[REDACTED]
3/2022/0383

I write in relation to the above planning application, land off Hawthorne Place, Clitheroe, BB7 2HU.

On this application to vary condition 14 (Arboricultural Impact Assessment) there is a plan of the site within the Impact Assessment. This plan shows 50 houses with those around the public open space and pond missing. On the most recent layout of the landscaping plan dated 03/05/22 on application 3/2022/0351 and indeed other plans preceding, there are the proposed 57 houses.

DRAWING TITLE:
Tree Constraints & Draft Protection Drawing

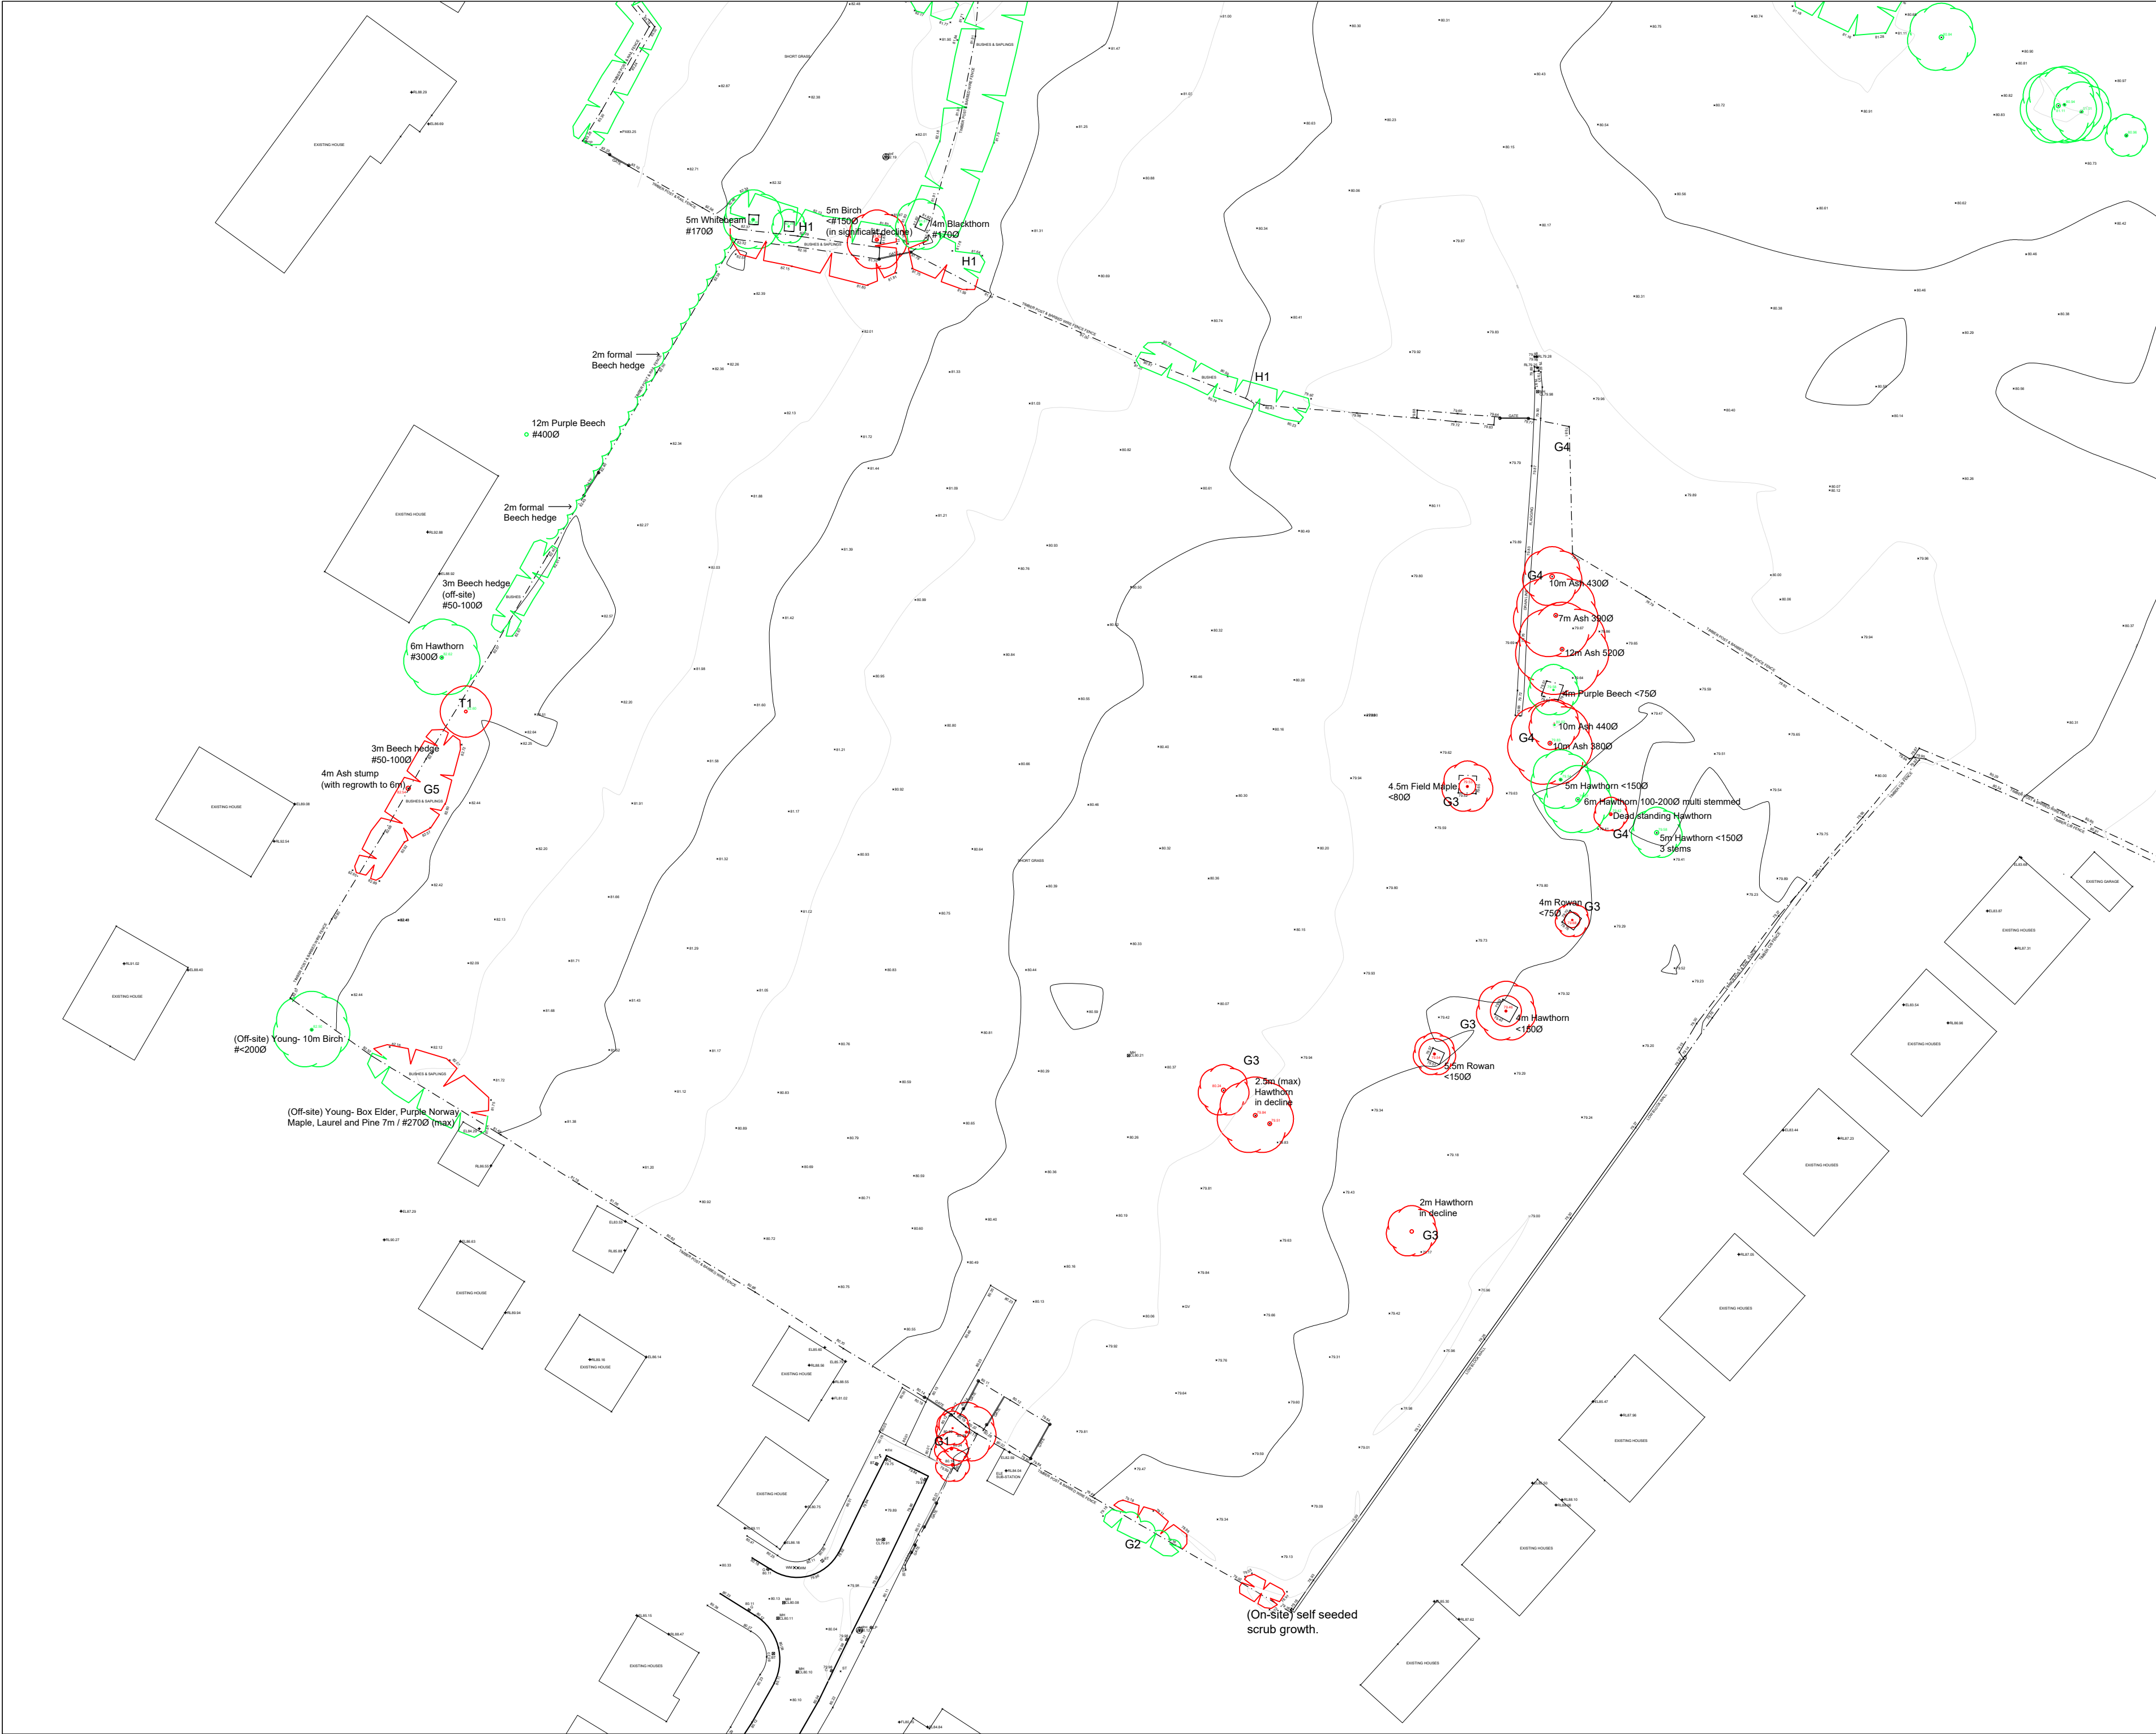
We are concerned that this is therefore not a true representation of the plans and worry that the impact of the houses around this area will not be taken into consideration and may lead to even more mature trees being removed. We seek reassurance that the expert surveying this plot on behalf of Persimmon Homes has been made aware that the plan they have drawn does not match the plans provided by Persimmon.
